A417 MISSING LINK – FURTHER REPRESENTATION

ON BEHALF OF MR I F MEDLOCK, [REDACTED]

5th MAY 2022

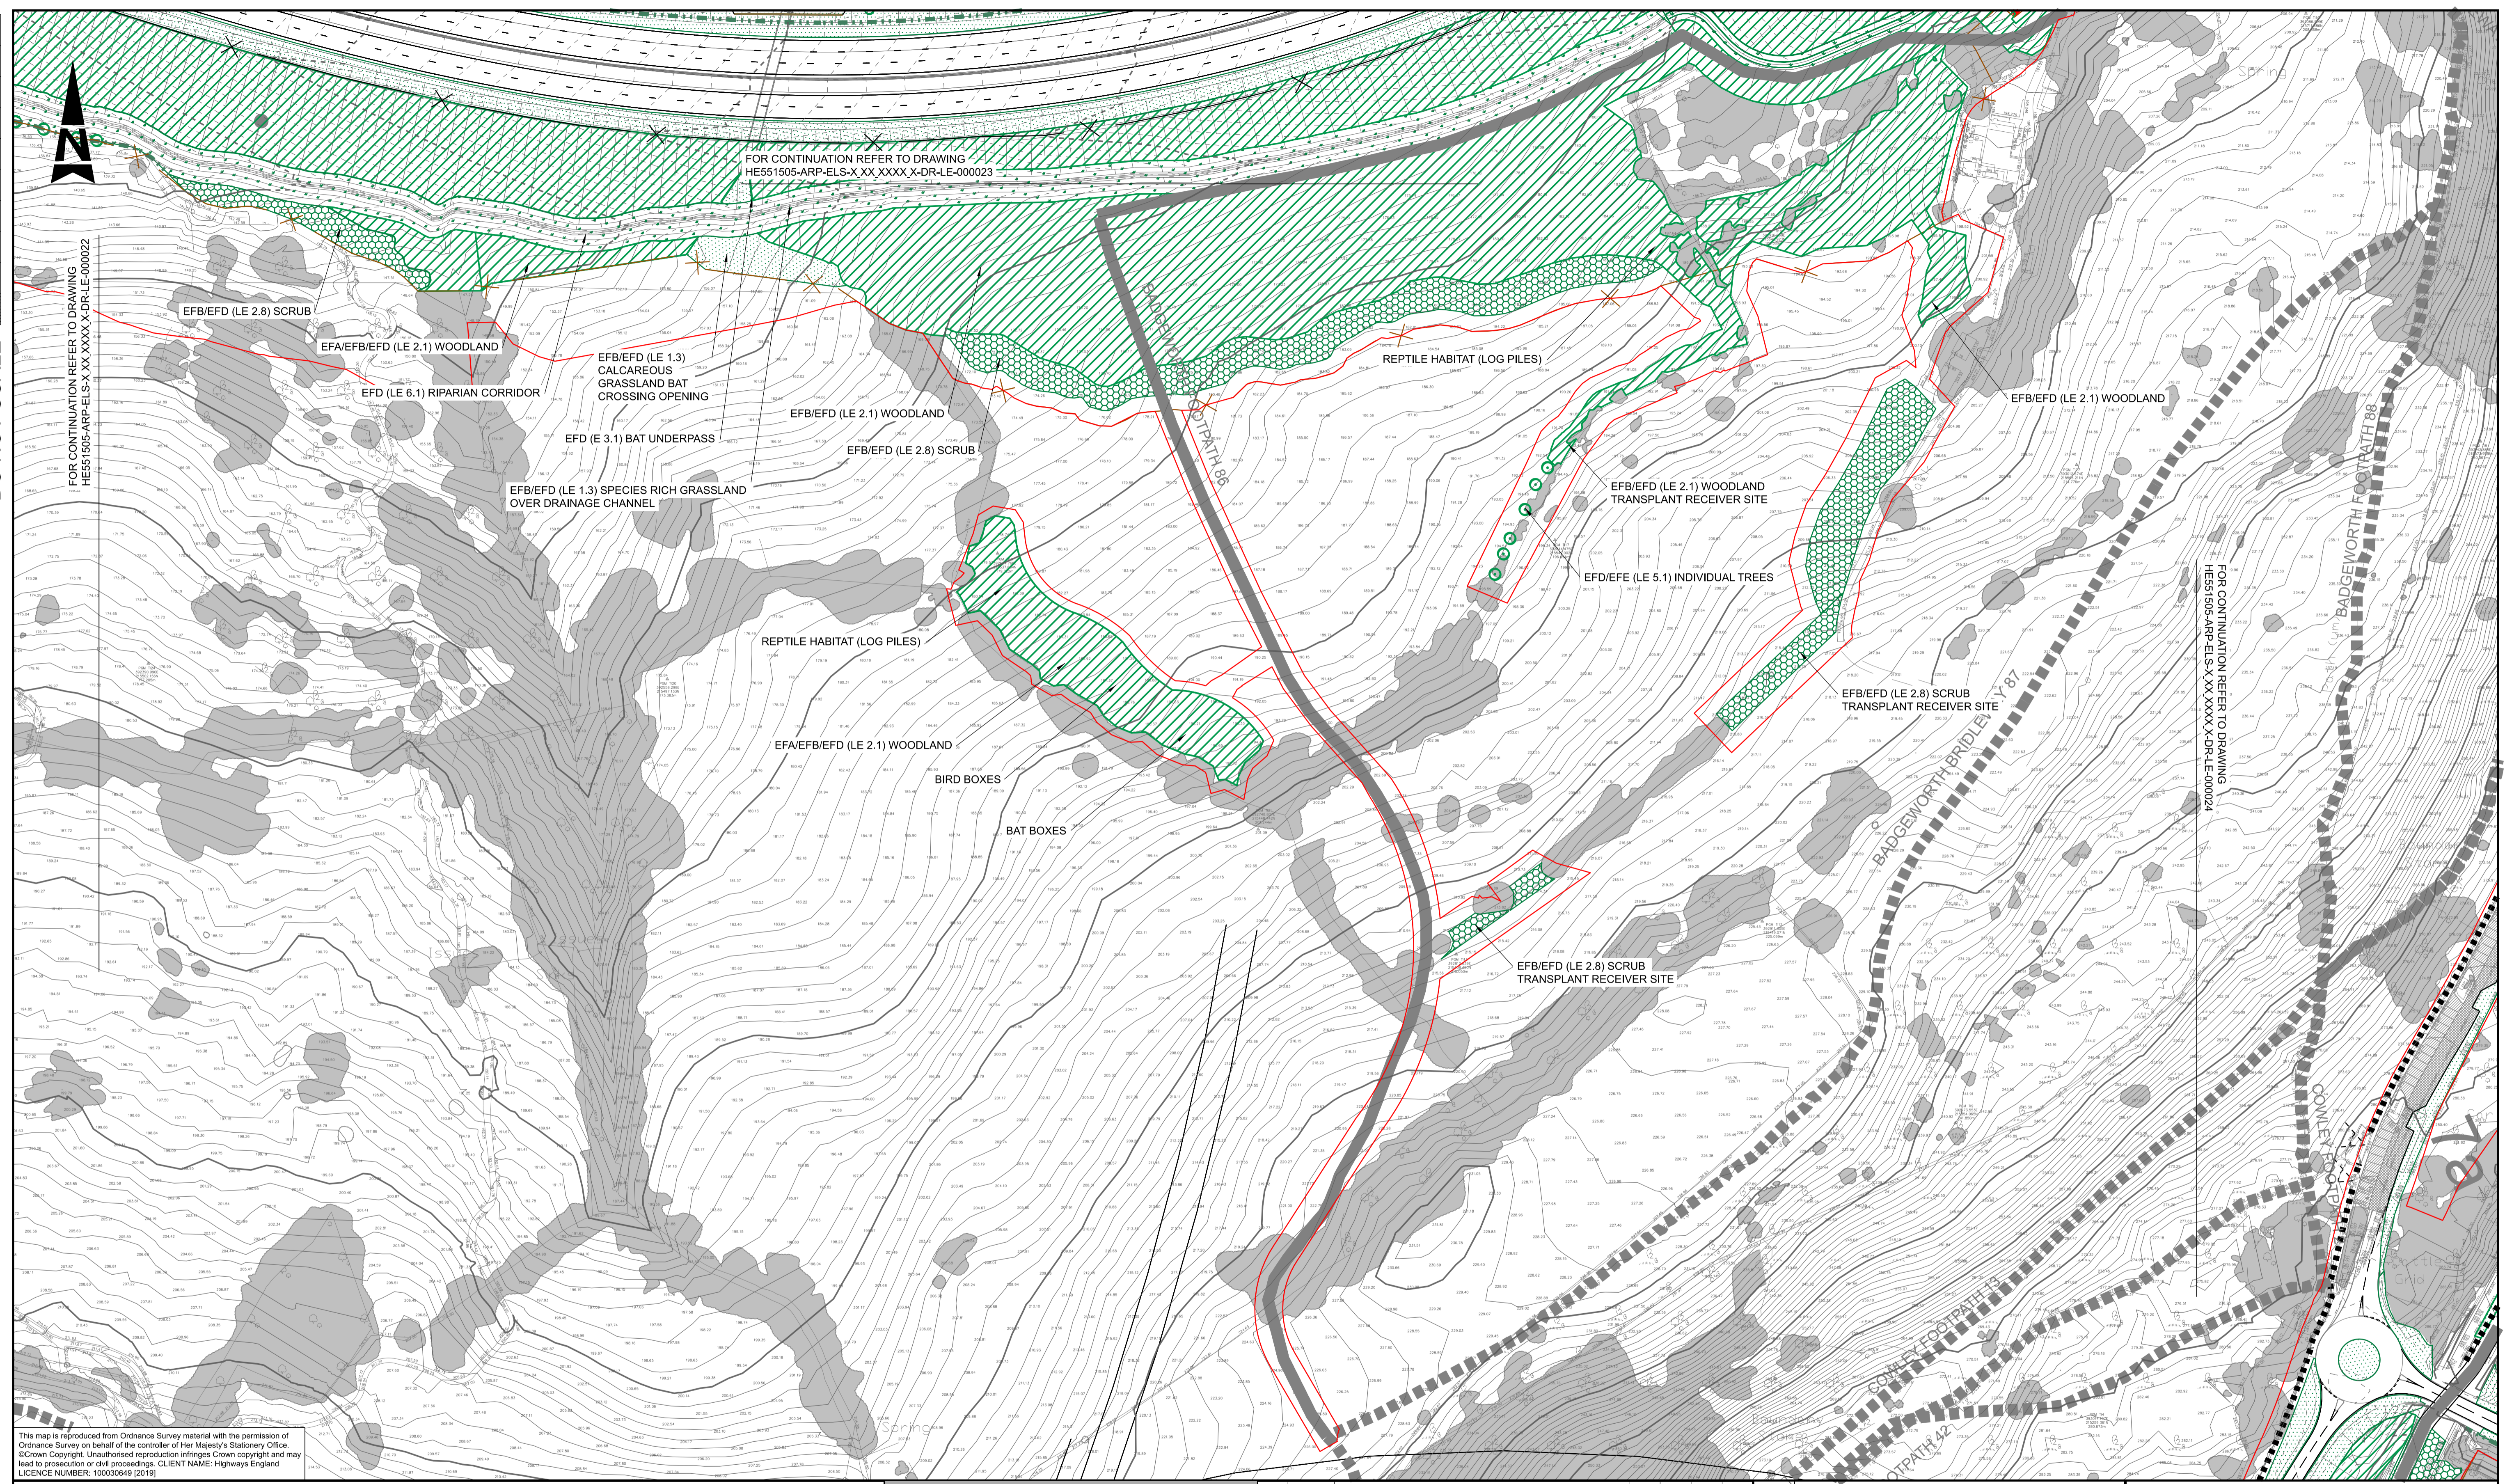
National Highways have requested an acquisition of an estimated 10 hectares of land for Environmental Mitigation. The area is estimated as we have not been provided with the exact area which is situated on our clients property to the north of the proposed road. The acquisition of this land raises the following points:

- i) A significant area of mitigation is required on our client's land, but there appears to be little other mitigation on other sizeable land holdings in the area. Why should this land be acquired by National Highways when a fairer system would be aggregating the mitigation over a wider area?
- ii) We have consistently requested an alternative approach; which is to be provided with the general terms of a S. 253 Management Agreement. We understand this agreement could be managed by our client, which is our favoured approach rather than being forced to release freehold ownership at below market value. As yet, we await a pro forma agreement to consider.

A Compound is proposed on land which is subsequently proposed to be utilised for environmental mitigation. How can the destruction of valuable grassland for a period of several years (until, presumably, at least 2025) for use as a Contractors Compound storing materials, offices, machinery, producing noise and air pollution and thereafter be returned to habitat? The two land uses are incompatible and for the sake of the wildlife, a compound should not be considered if this location, given the environmental mitigation proposed above.
